## **Objection to proposed Metal Recovery and Recycling Facility (SSD 8375) 56-69 Tattersall Road, Kings Park**

This letter is our formal objection to the State Significant Development (SSD) Application for the metal recovery and recycling facility (SSD 8375) (the Proposal) at the 'Pick and Payless' site, 56-69 Tattersall Road, Kings Park (the P&P site). This letter has been prepared based upon our review of the documentation (Environmental Impact Statement (EIS) and associated technical reporting and plans) placed on public exhibition for SSD 8375.

This submission is made on behalf of Sell and Parker whom own and operate a number of properties on Tattersall Road, Kings Park. In particular, Sell and Parker own and operate the neighbouring metal recovery, processing and recycling facility at 45/23-43 Tattersall Road, Kings Park (the Sell and Parker site). This site is located immediately west of the P&P site.

Figure 2: Typical Section – Below Ground OSD, Source: S3QM

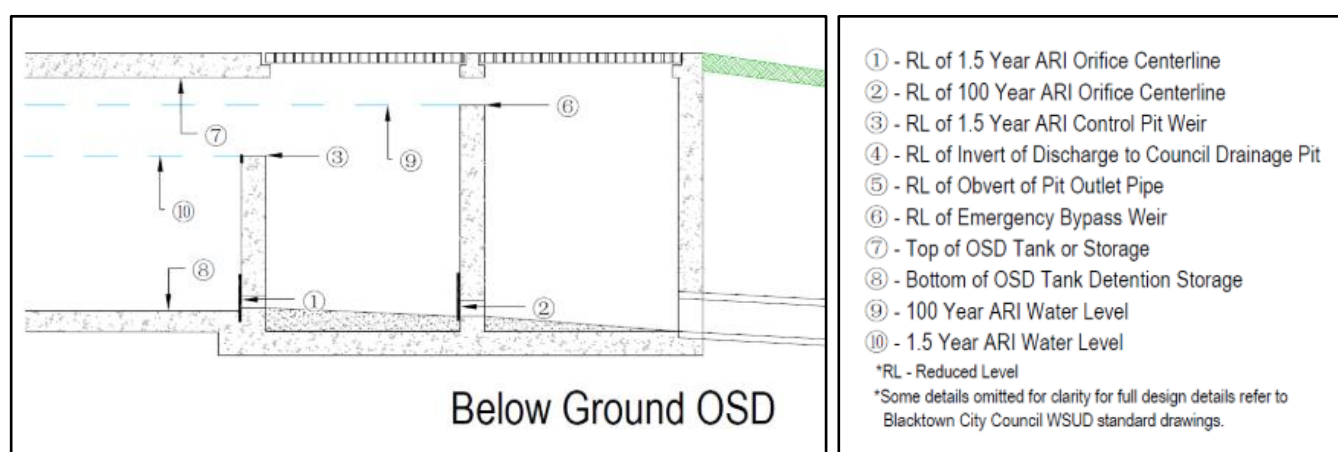
No.	Issue	Comment	EIS Reference	Initial recommendation
		Section 13.2 of the EIS indicates that agencies were not consulted during the preparation of the EIS. This is inconsistent with the SEARs and does not afford the opportunity for design changes (as required to respond to agencies) to be included within the EIS. Ultimately, a key step in the SSD assessment process has been excluded therefore reducing the validity of the EIS.	Section 13.2	in addition to comments received through public exhibition). These documents should be placed on public exhibition to provide relevant stakeholders the opportunities to comment, particularly in regard to how the design has responded to key issues.
3	Planning approvals	<p>Section 3.5 of the EIS provides an overview of previous and existing planning approvals for the P&amp;P site. Based on a review of these, it is clear that there are overlaps between the built-form and activities identified in these approvals. Based upon Section 4.1 of the EIS it is understood that the Applicant intends to surrender the current Development Applications (DA) (DA 96-185, DA 18-01273 and DA 18-02214) for the P&amp;P site.</p> <p>Notwithstanding this, Section 4.3.1 identifies that that a “separate application will be submitted to Council for the extension of the driveway width”. Therefore, a separate DA, which overlaps the SSD 8375 (if approved), could potentially be active on the P&amp;P site.</p> <p>In addition to this there are a number of potentially unlawful works that are not consistent with existing approvals (refer to Section 4 of this submission below).</p> <p>Further, as identified below the impact assessment provided does not adequately consider the existing P&amp;P operations (namely the car storage) in the context of the Proposal, which further creates complexities with the regulation of the P&amp;P site (i.e. preparation of appropriate conditions of consent).</p> <p>The approach undertaken by the Applicant in overlapping approvals is considered inconsistent with standard practice for approvals under the <i>Environmental Planning and</i></p>	Section 3.5 and Section 4.3.1	The Development Description should be updated to include the eastern driveway width extension and nominate works required for the eastern roadway for clarity. Further impact assessment should be undertaken accordingly.

INTERNAL SWEPT PATH ANALYSIS - 19M ARTICULATED VEHICLES & 8.8M MR

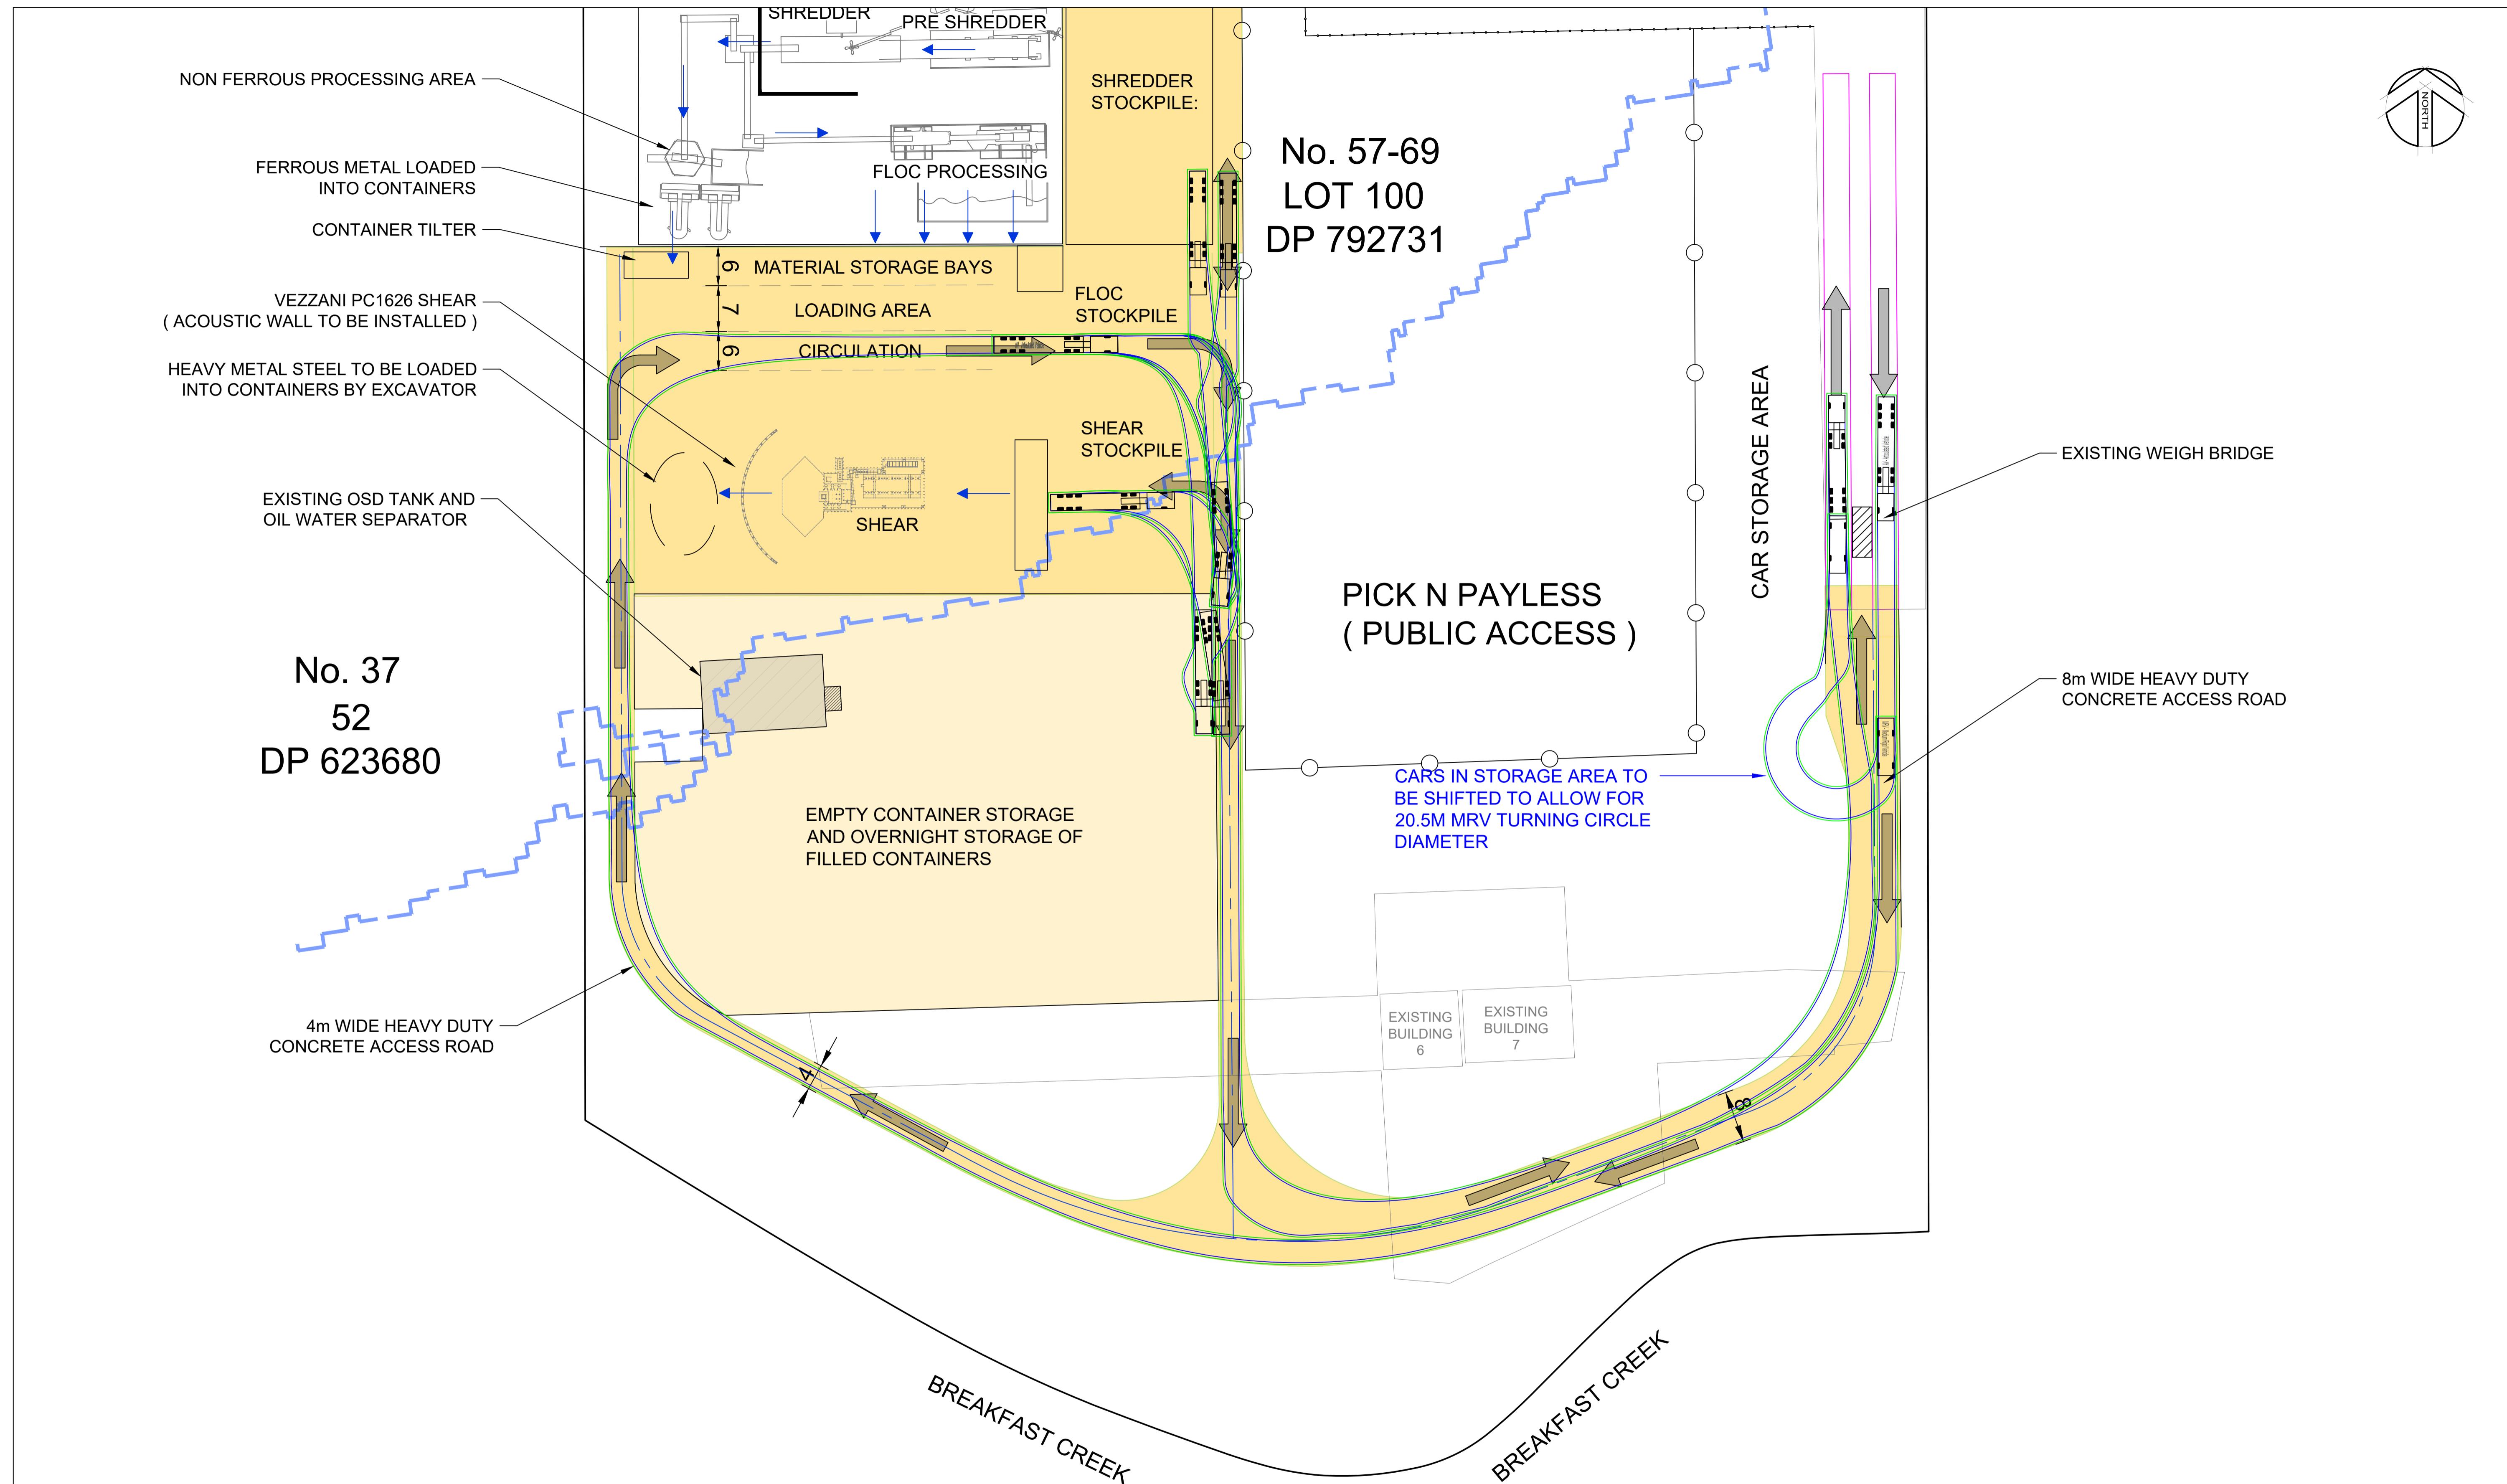
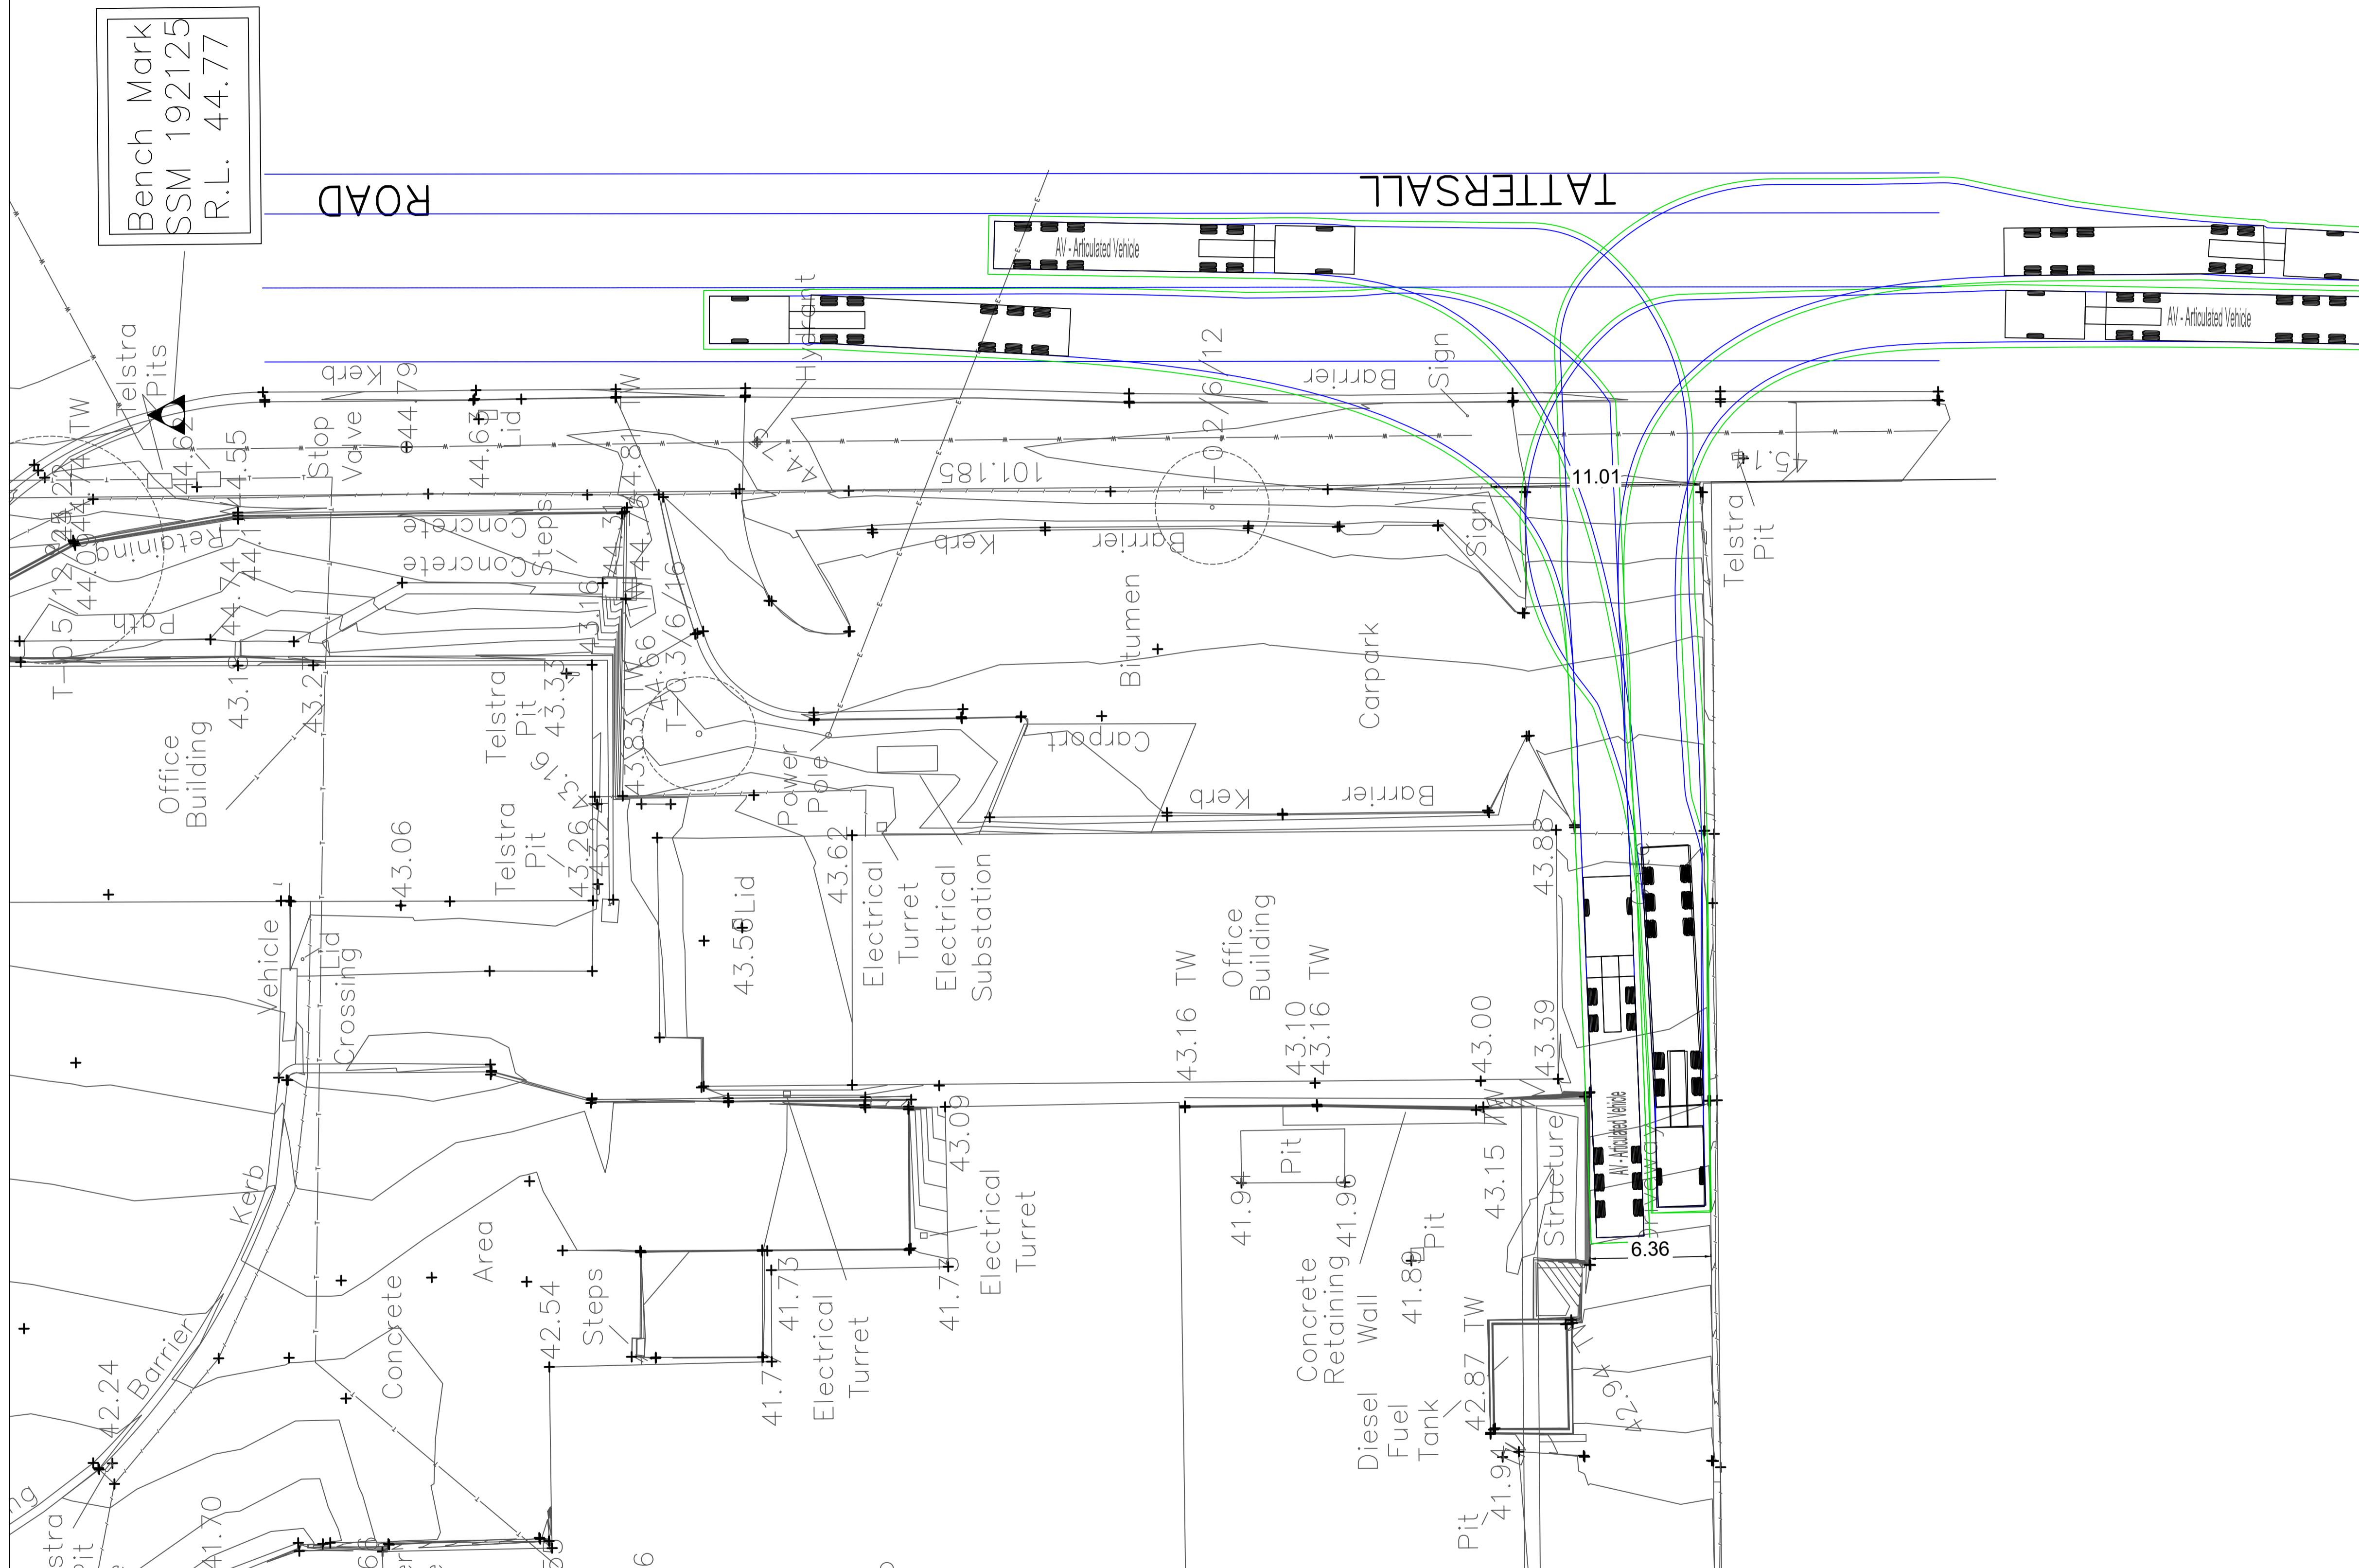
Section 4.2 indicates that medium rigid vehicles would enter the eastern driveway, 'weigh in' and then U-turn and enter the western driveway. The location of the proposed turning	Section 4.2, Appendix A	The Development Plan (Appendix A) should be

No.	Issue	Comment	EIS Reference	Initial recommendation
		<p>circle has been included within the Traffic and Parking Impact Assessment (Appendix M of the EIS) however has not been shown on the Development Plan (Appendix A of the EIS). Further, the Traffic and Parking Impact Assessment indicates that cars within the storage area are to be relocated to accommodate this turning circle. This has not been identified on the Development Plan.</p> <p>It seems that works relating to the construction of the turning circle have not been included within the EIS and therefore an adequate impact assessment (other than traffic) has not been undertaken.</p>	and Appendix M (Appendix B)	<p>updated to identify the works to be undertaken to accommodate this turning circle.</p> <p>Further impact assessment should be undertaken to consider these works, ensuring a complete assessment of the Proposal has been undertaken.</p>
